# **The Lake Lothing (Lowestoft) Third Crossing Order 201[\*]**

## **Document SCC/LLTC/EX/89: Responses to the non-statutory consultation on proposed non-material changes to the Scheme**

Document Reference: SCC/LLTC/EX/89

Date: 5 March 2019

NEW ACCESS ROAD LONG SECTION
WORK NO. 5
WORKS PLANS SHEET 2
Horizontal Scale = 1:500, Vertical Scale = 1:100

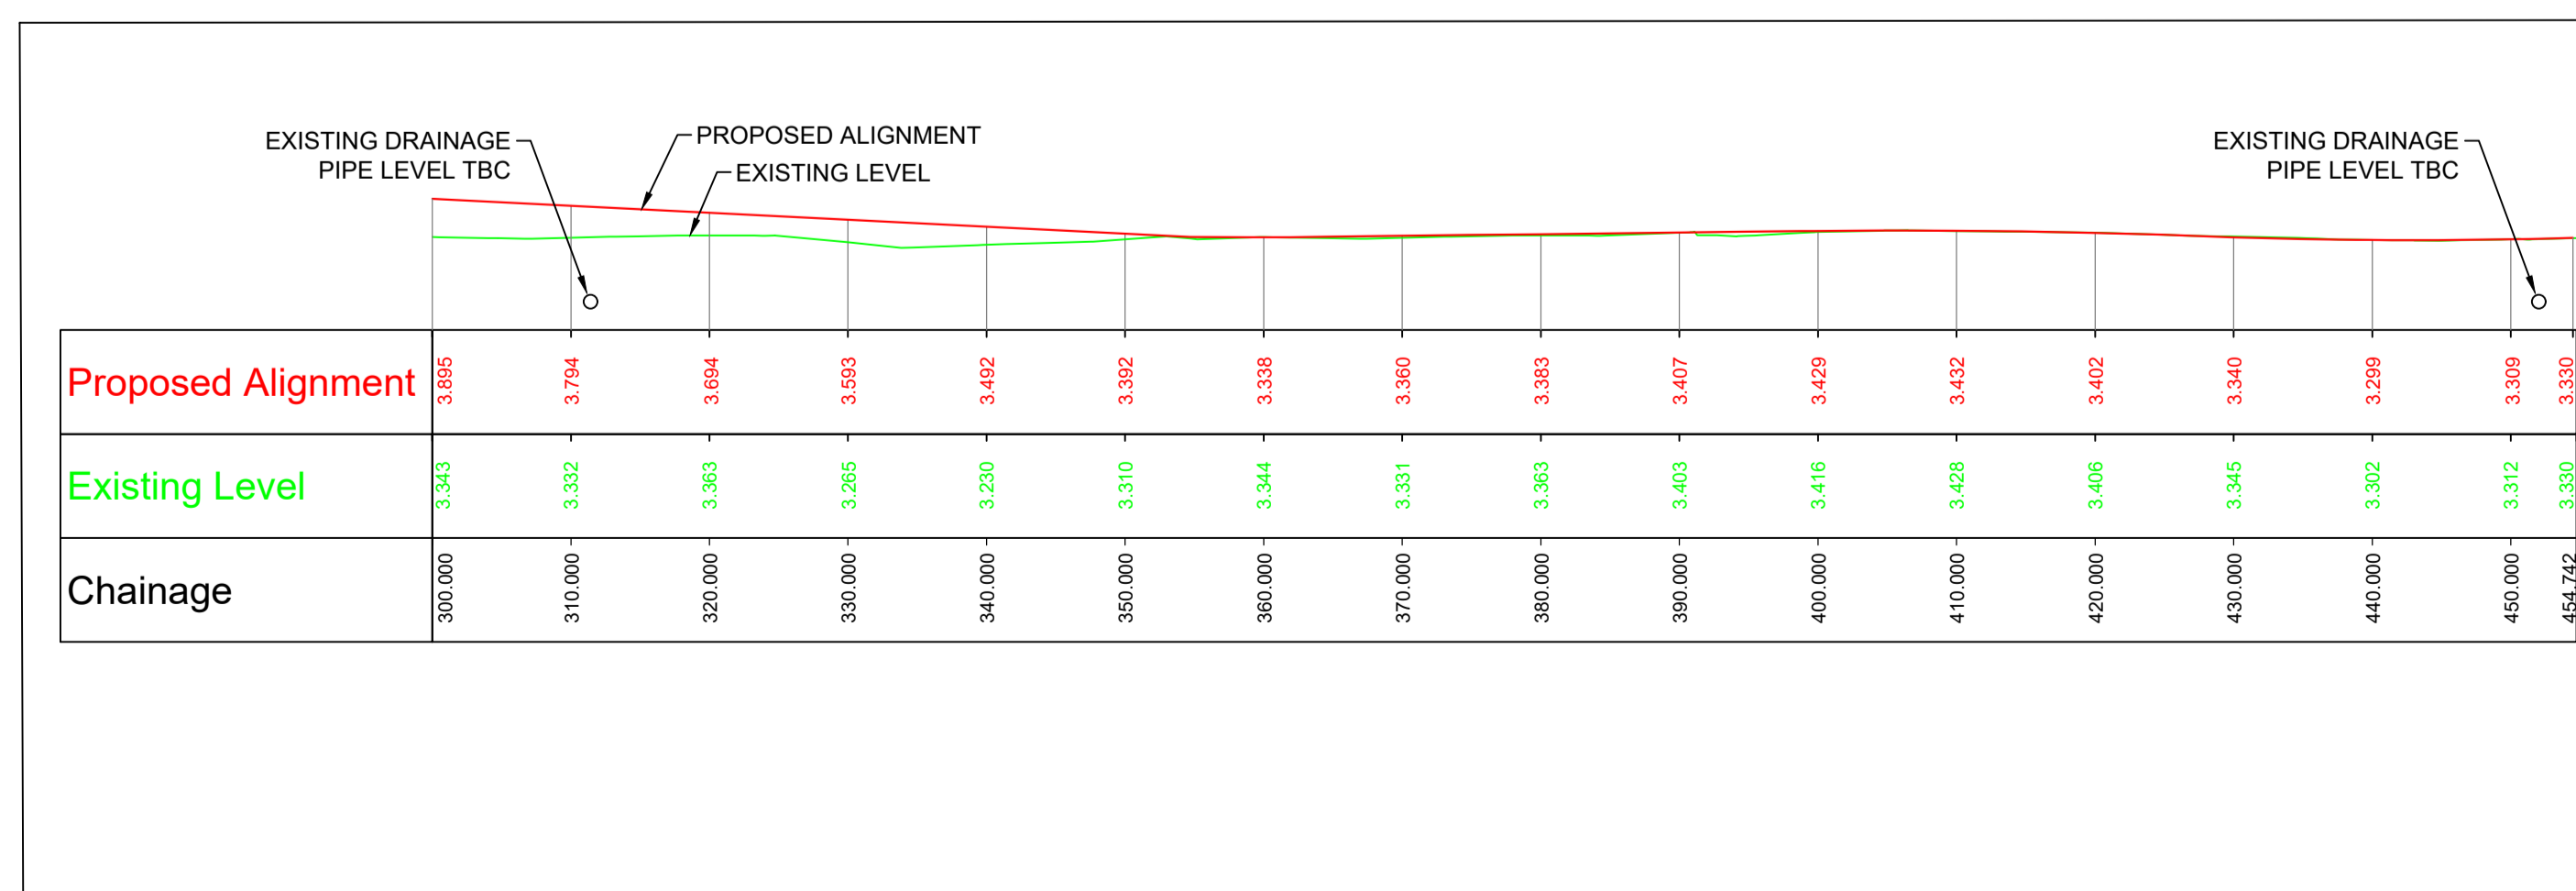
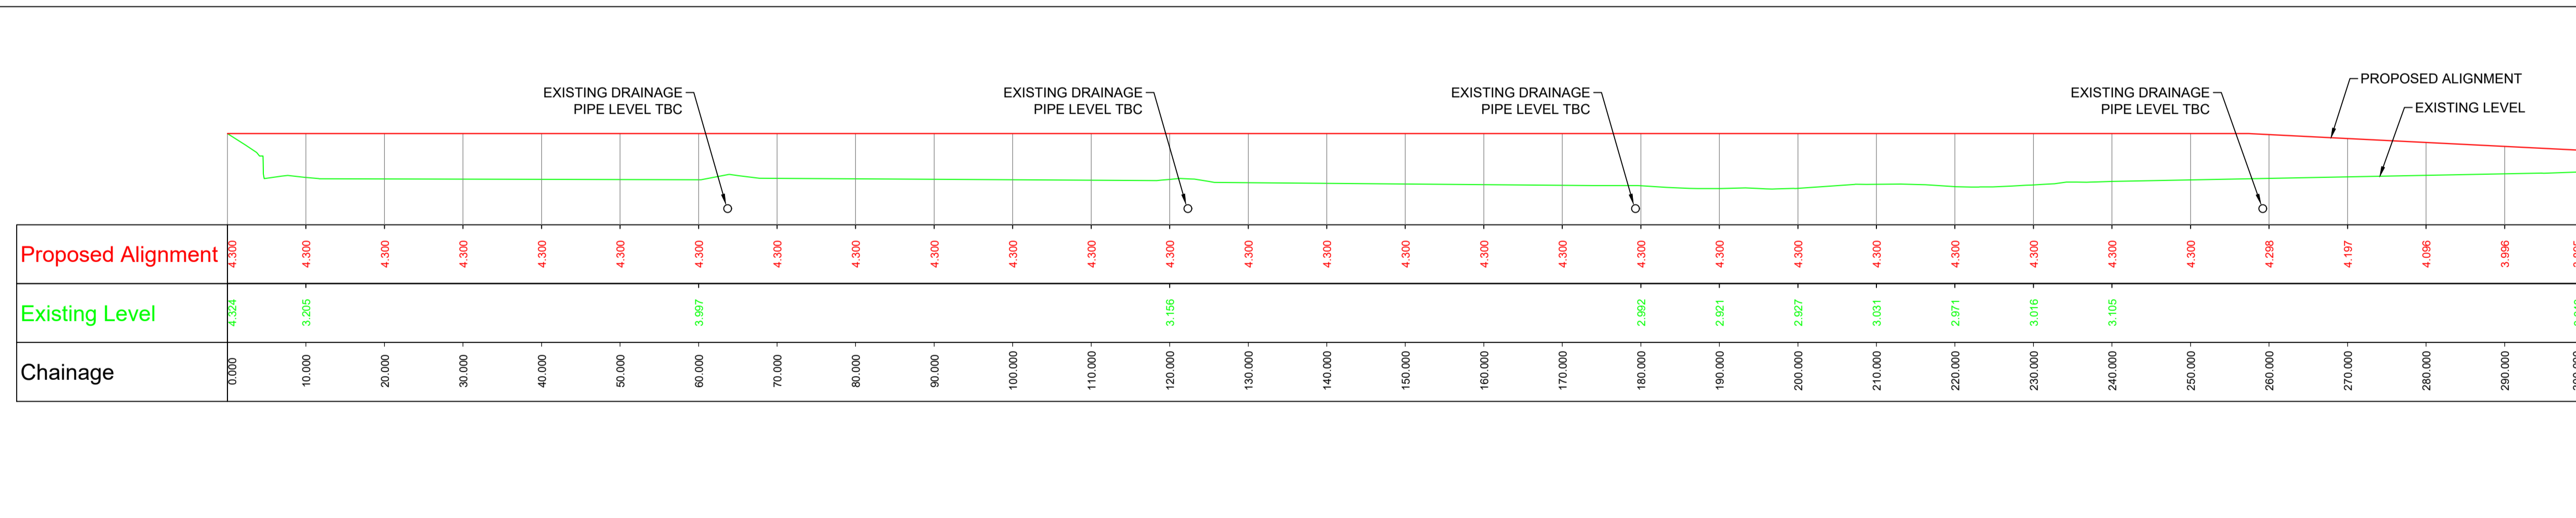
We note that it proposed to revised the existing alignment of new access road and create a new junction for the benefit of the 'Jen-Wen' site.

The re-aligned section of access road appears to cross an existing surface water sewer in Anglian Water's ownership. As above this sewer is essential to Anglian Water's ability to perform our duties as a sewerage undertaker.

We would welcome clarification from Suffolk County Council in relation to whether it is intended that the existing sewer would form part of the new public highway and how access would be maintained.
